July 23, 2026

El Paso County Planning & Community Development
Attn: Miranda Benson, Associate Planner
2880 International Circle
Colorado Springs, CO 80910

**SUBJECT: Monument Academy East Campus – 4303 Pinehurst Circle
Site Development Plan – Letter of Intent**

ALTERNATIVE LANDSCAPE
PLAN

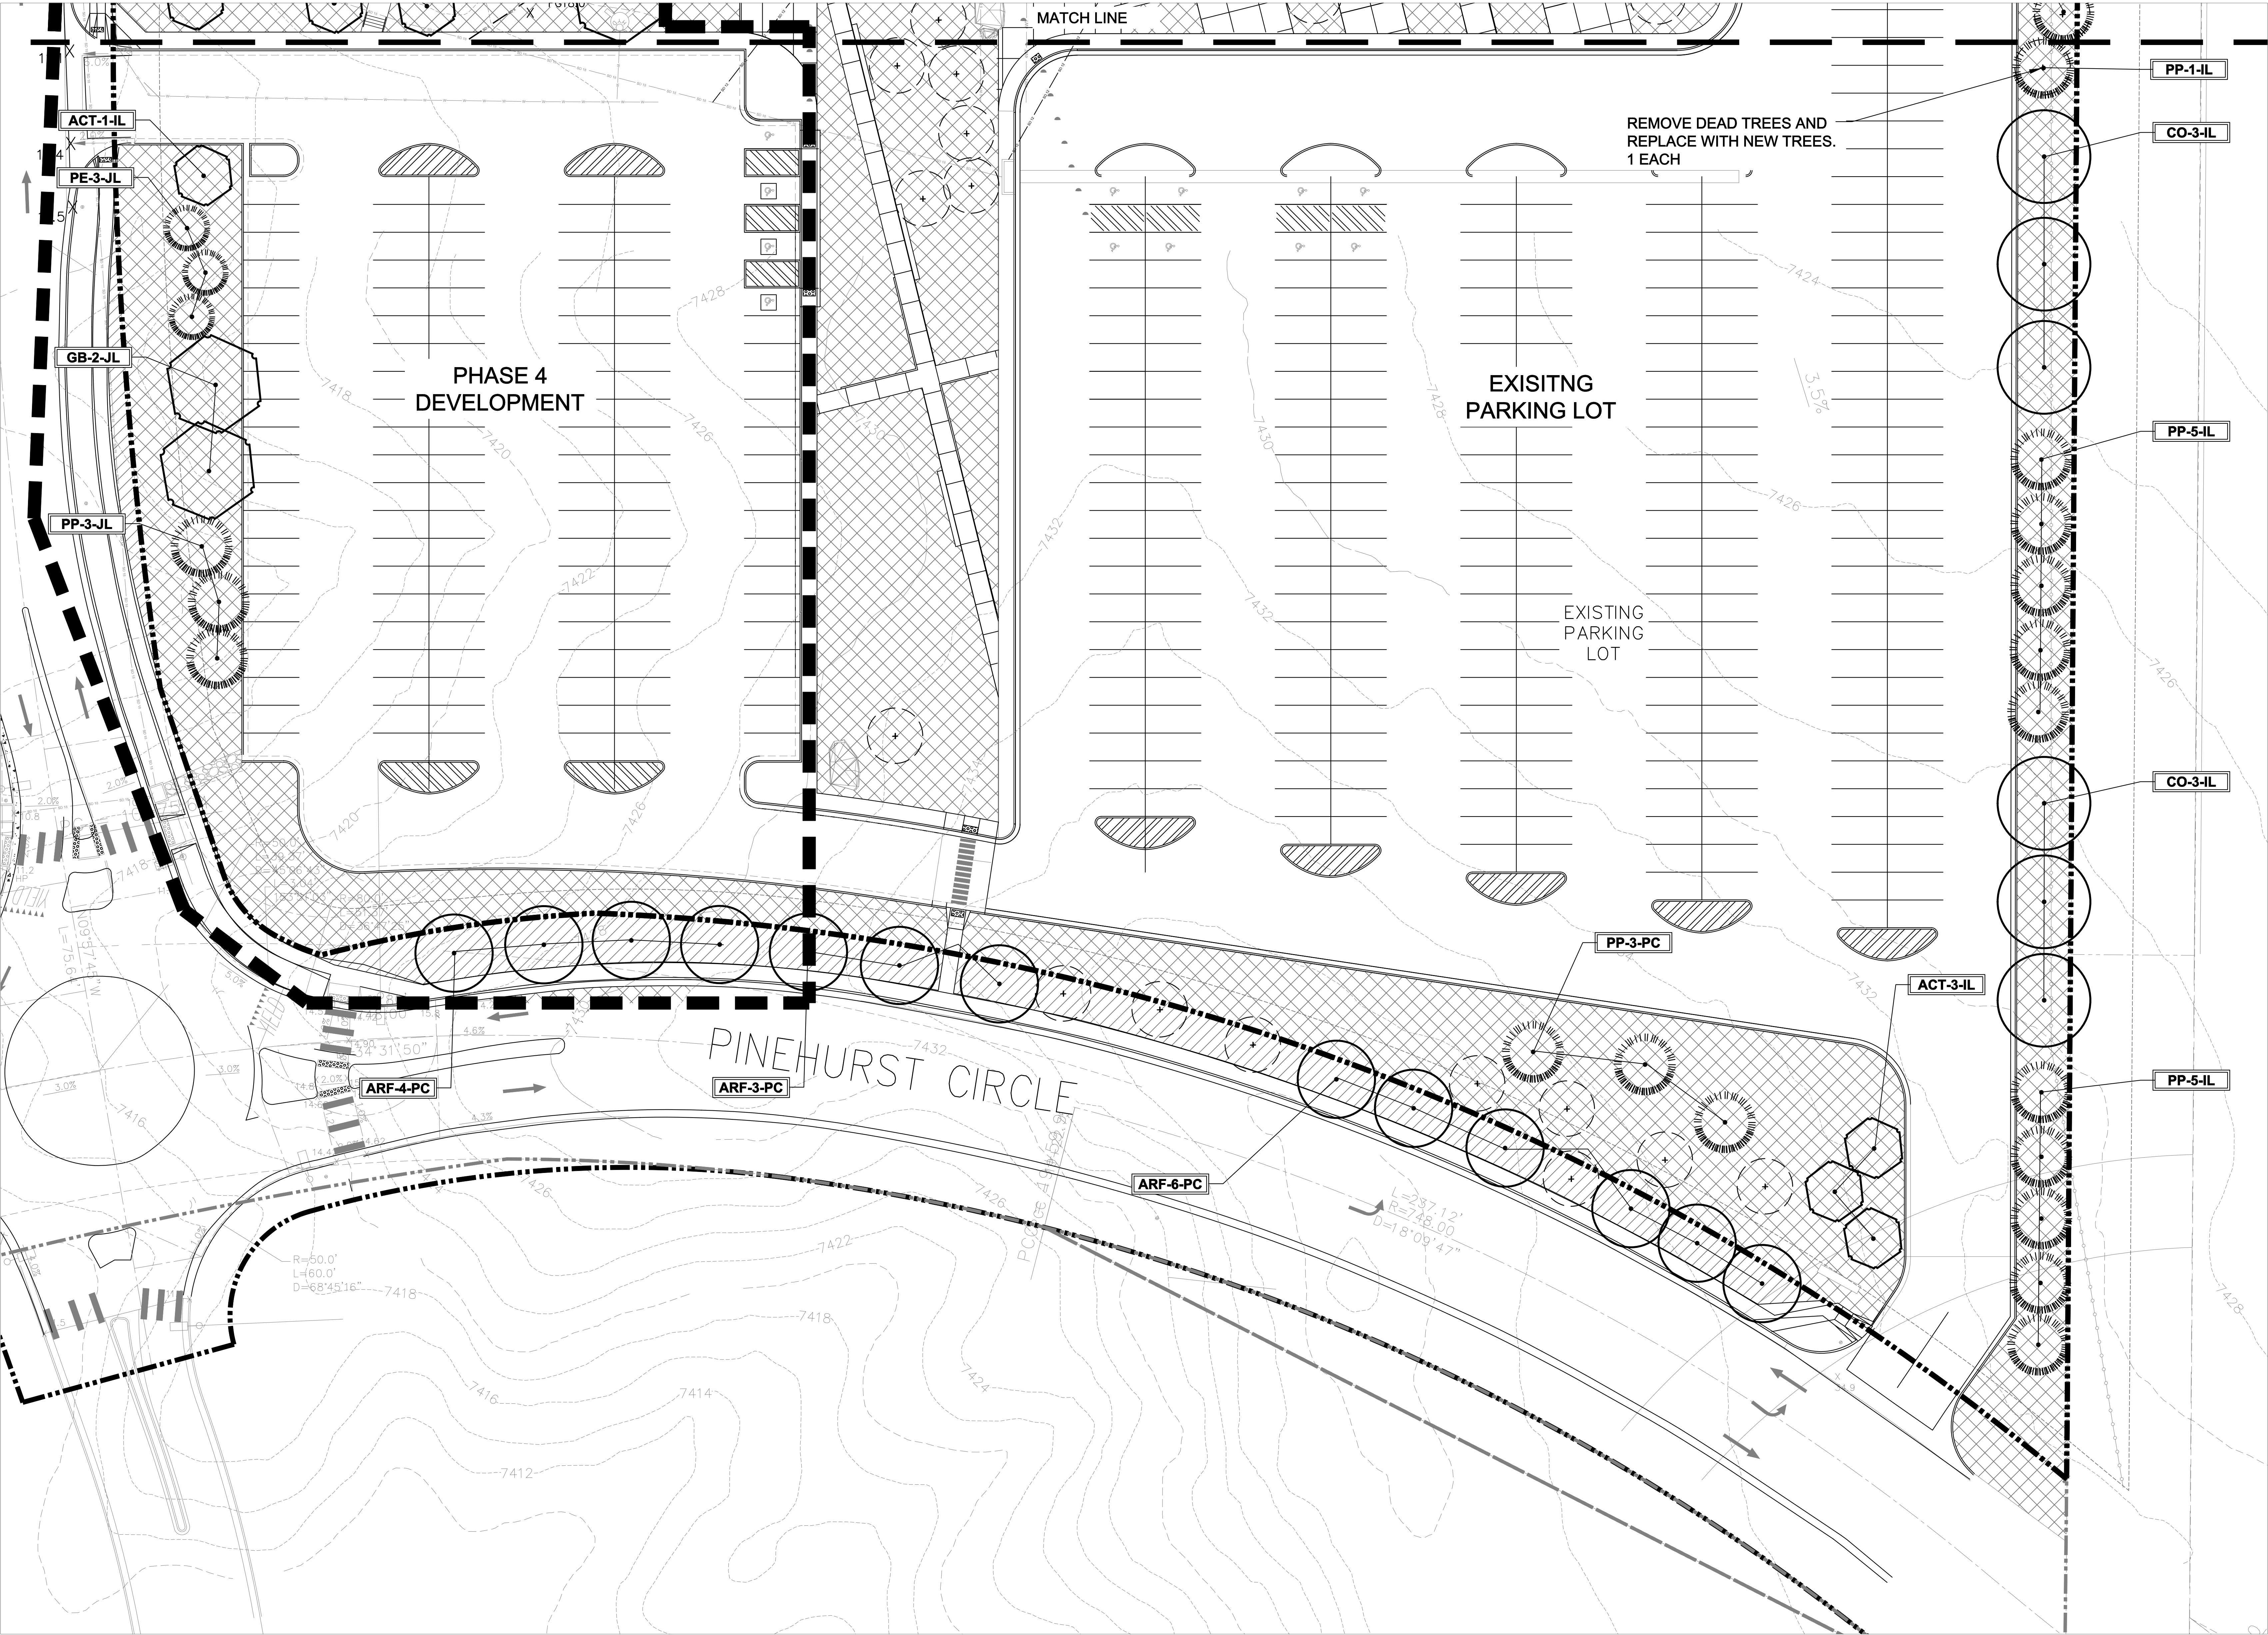
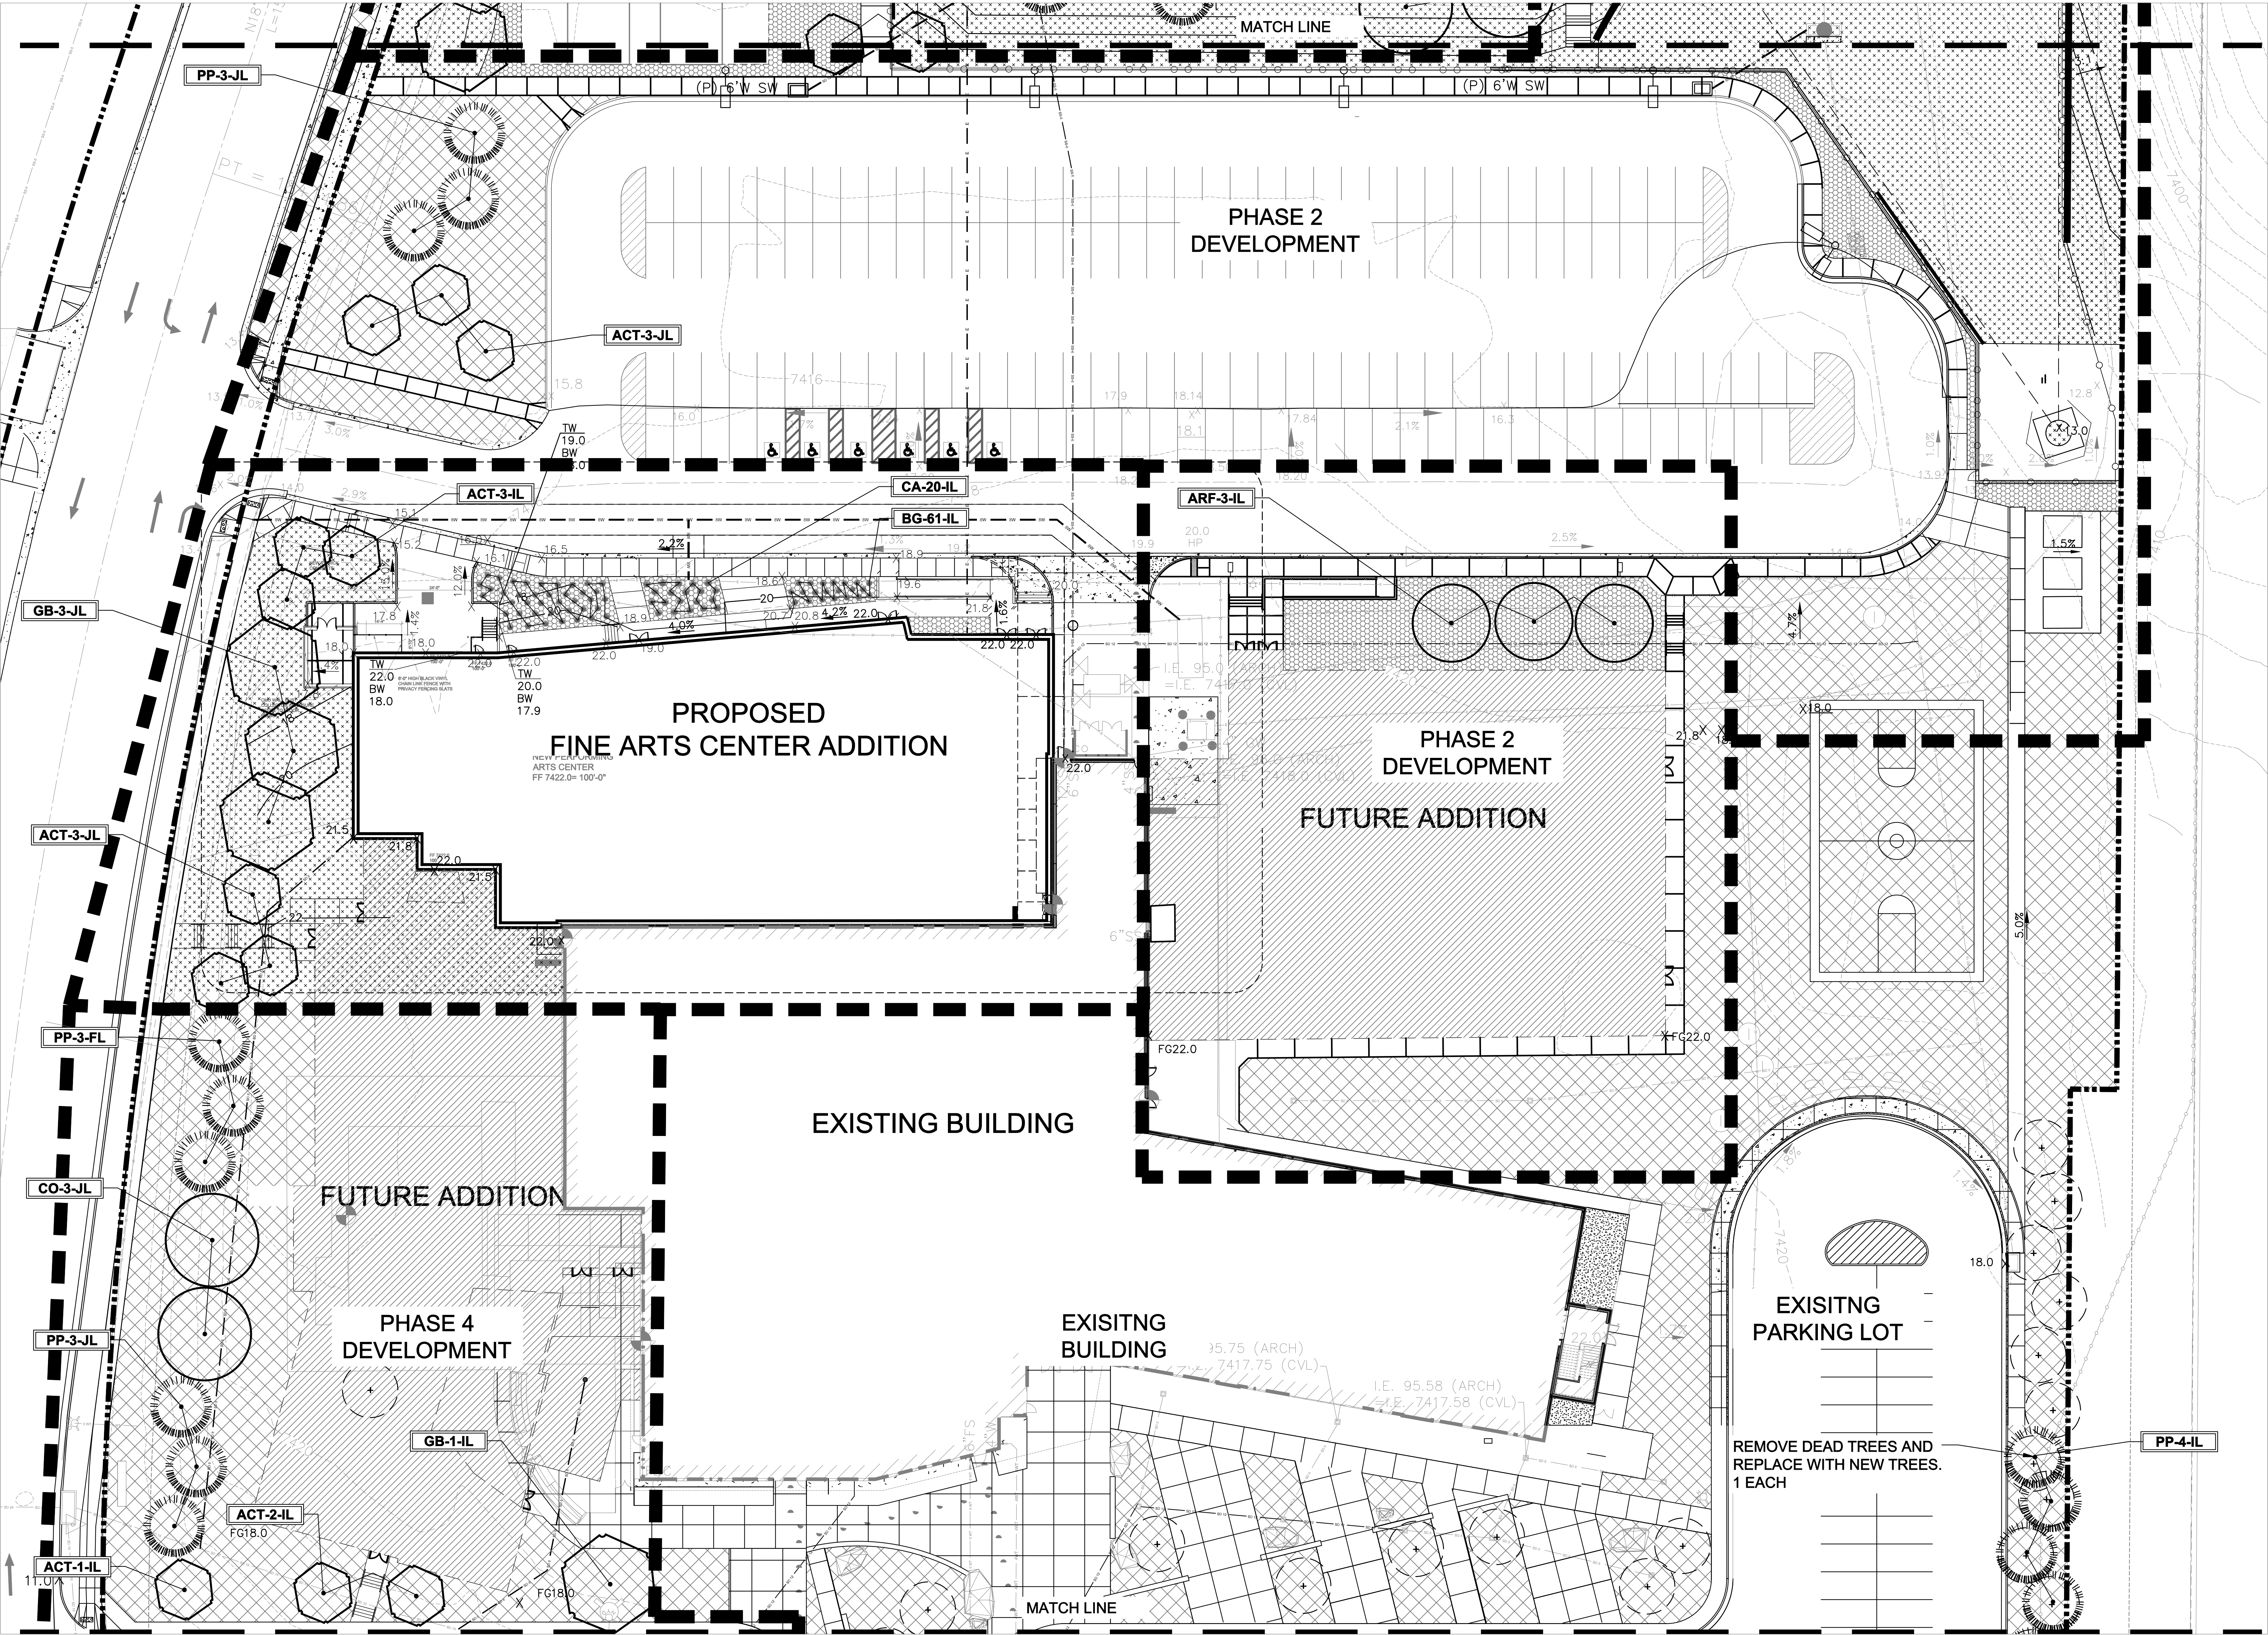
1. **Section: 6.2.2.E.2.a-b. Requirement for Non-Residential Uses, Minimum required Landscape interior area and Tree Count:** Monument Academy is proposing an alternative landscape plan with a reduced interior tree count provided based on limited resources. The proposed site design adequately meets the functional needs of the school and provides appropriate aesthetic landscaping. PPR199 allowed for a reduced number of trees. Internal landscaping was not waived.

2. **Section 6.2.2.C.2. Parking Lot Islands: Islands, fingers, and corners are required to be incorporated into all parking lots of 15 parking spaces or more in area. One island shall be provided for every 15 spaces.** Monument Academy is proposing an alternative landscape plan deleting the tree islands or an appropriate alternative design that meets the intent of the Code. PCD Director does not have the authority to diminish the total requirement. Include islands or an appropriate alternative design that meets the intent of the Code. to snow plowing in the parking lot. The proposed site design adequately meets the functional needs of the school without having tree islands with curb and gutter.

4. **Section 6.2.2.C.5. Required Parking Lot Screening: 36" landscape shrubbery screen.** Monument Academy is proposing an alternative landscape plan deleting the 36" shrubbery parking lot screening requirement. PCD Director does not have the authority to diminish the total requirement. Provide parking lot screening or provide detail of an alternative proposal. The Landscape Plan appears to show landscaping around the parking lot areas. boundary. Due to the large size of the parking lot, the proposed site design appears to show landscaping around the parking lot areas. stacking concrete parking lot screening requirements, while providing an appropriate program of landscape plantings for the school site.

5. **Section 6.2.2.D. Privacy fence between residential / non-residential uses.** Monument Academy is proposing an alternative landscape plan deleting the privacy fence typically required between residential and non-residential uses. PCD Director does not have the authority to diminish the total requirement. Roadway landscaping and buffering between differing uses may overlap. The Landscape Plan appears to show landscaping along all property boundaries. site boundary, existing residential development, and Monument Academy. Fencing is not required: non-residential
